21 October 2020

SSD-10291 – St Luke’s Grammar School – Response to Submissions

Brendan Gavin
Principal Planner

4 ELEVATION WEST
1:200

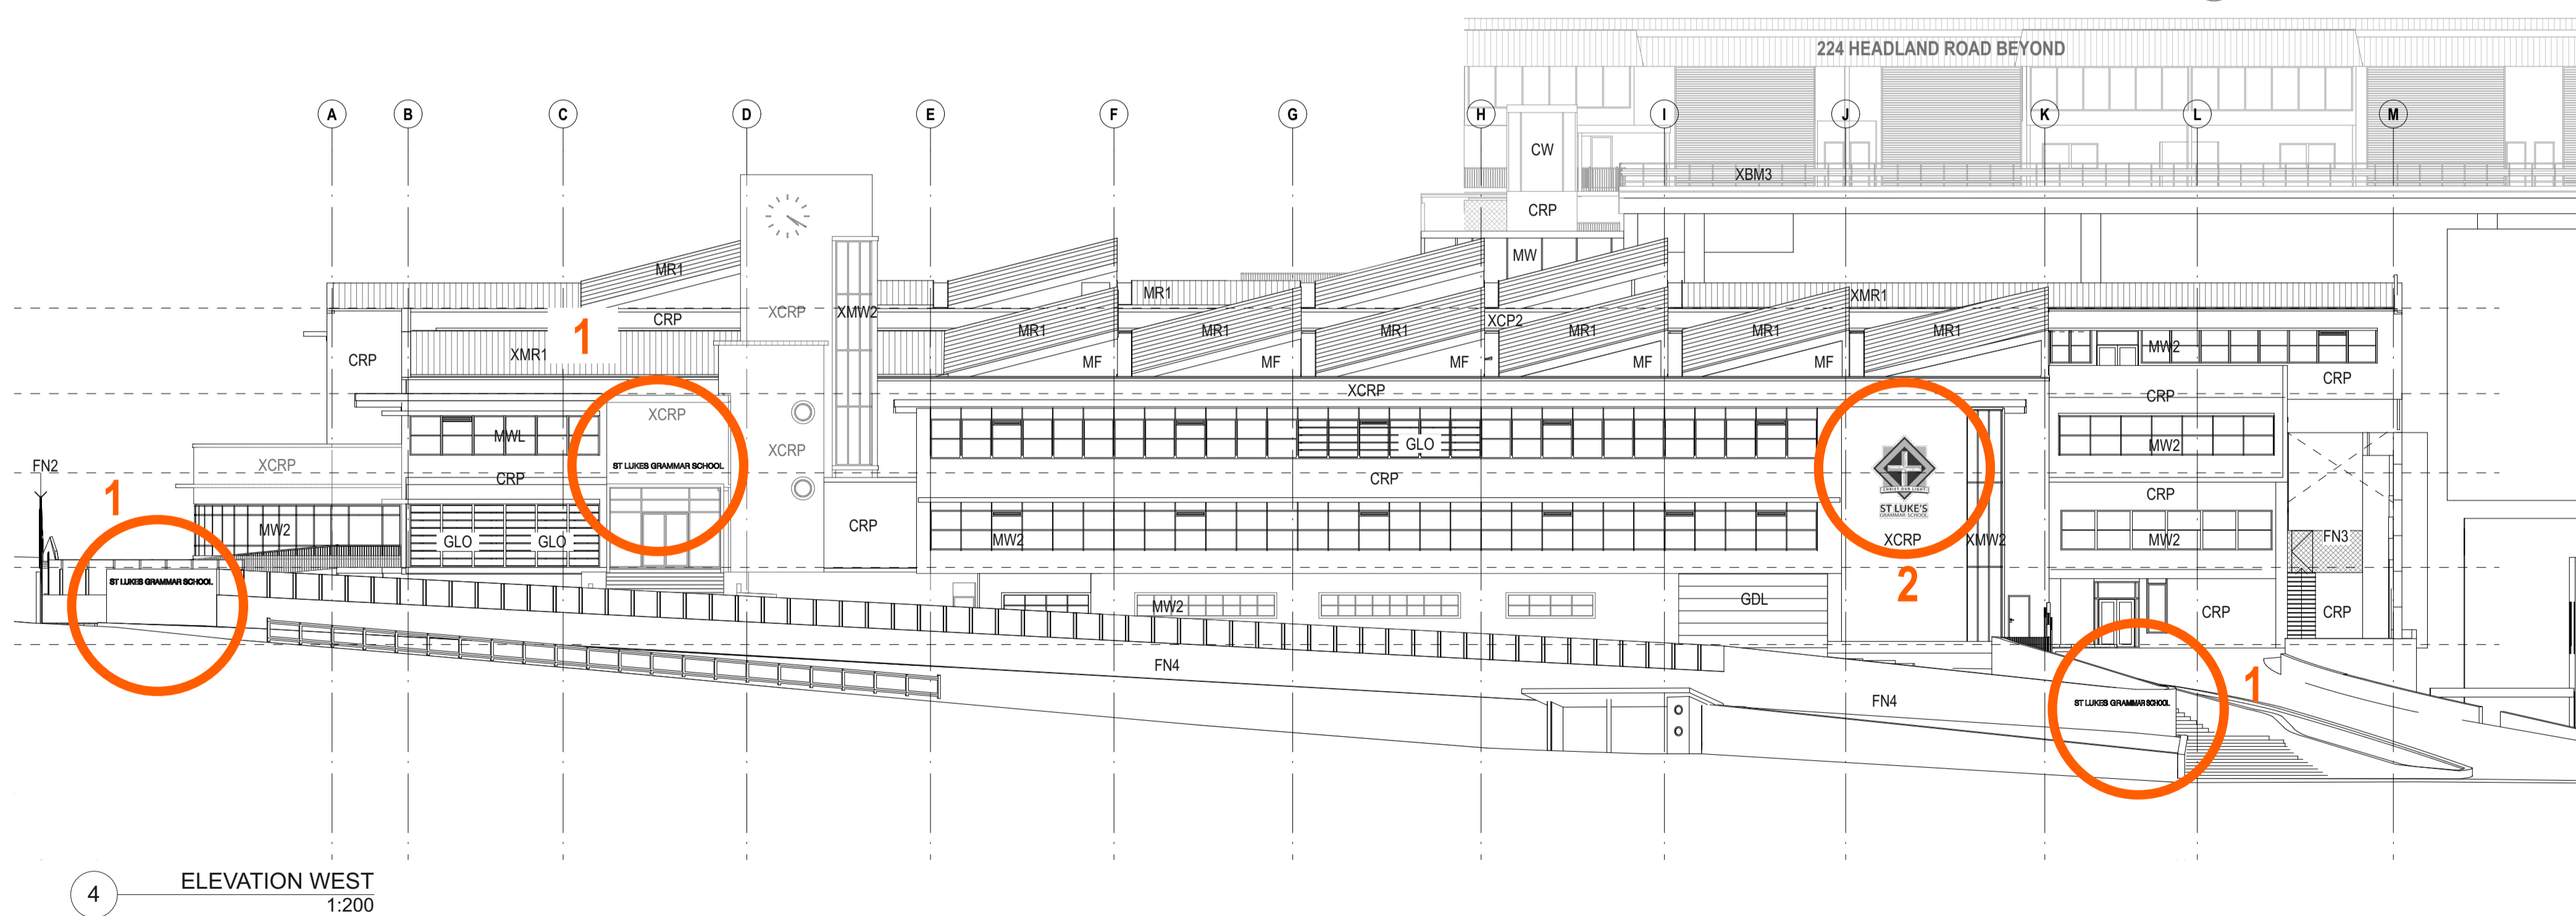
Heritage notes the response regarding proposed Sign 2. On balance, Heritage can tolerate the size of this sign.

1 ELEVATION WEST
1:200

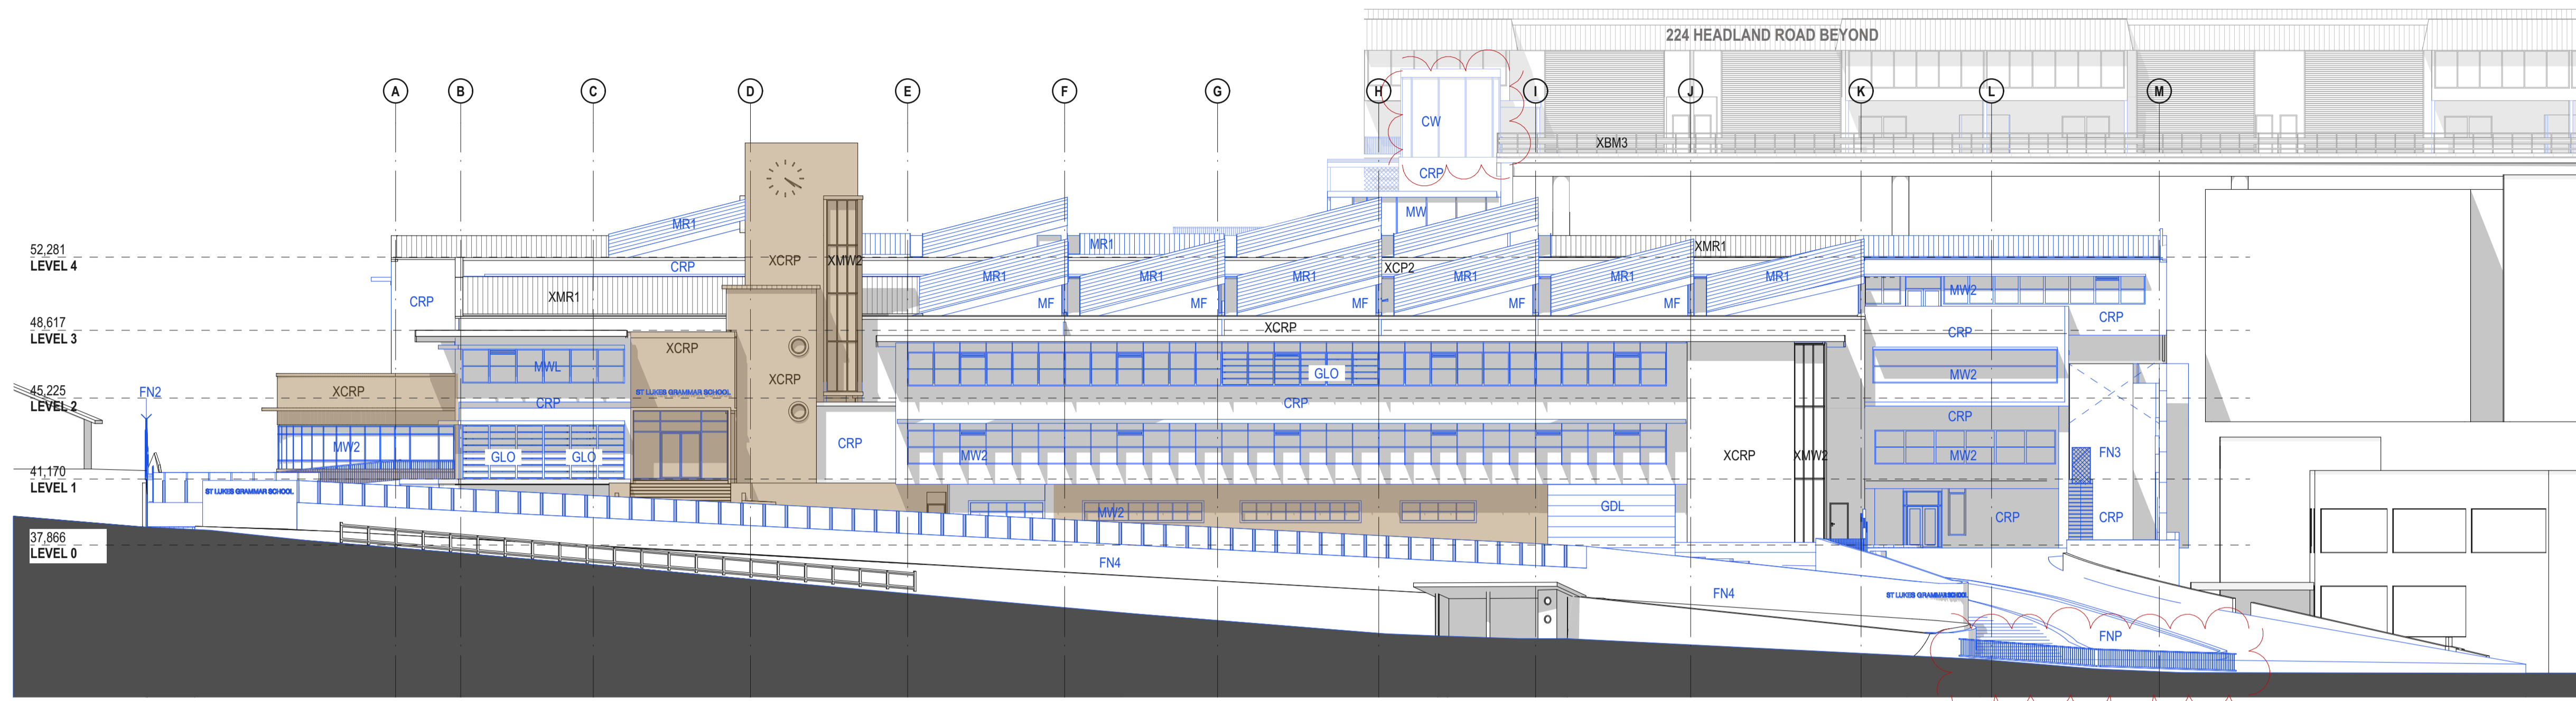
Heritage disagrees with the proposed column interpretation strategy on the western façade of larger fins painted in a deep blue colour. Heritage would prefer that the fins along this elevation remain the same size and colours.

Heritage notes the revised colour scheme and wishes to thank the applicants for addressing this matter. Heritage strongly supports this colour scheme with only a minor amendment. The shading fins should only be painted in the two lightest blue colours.
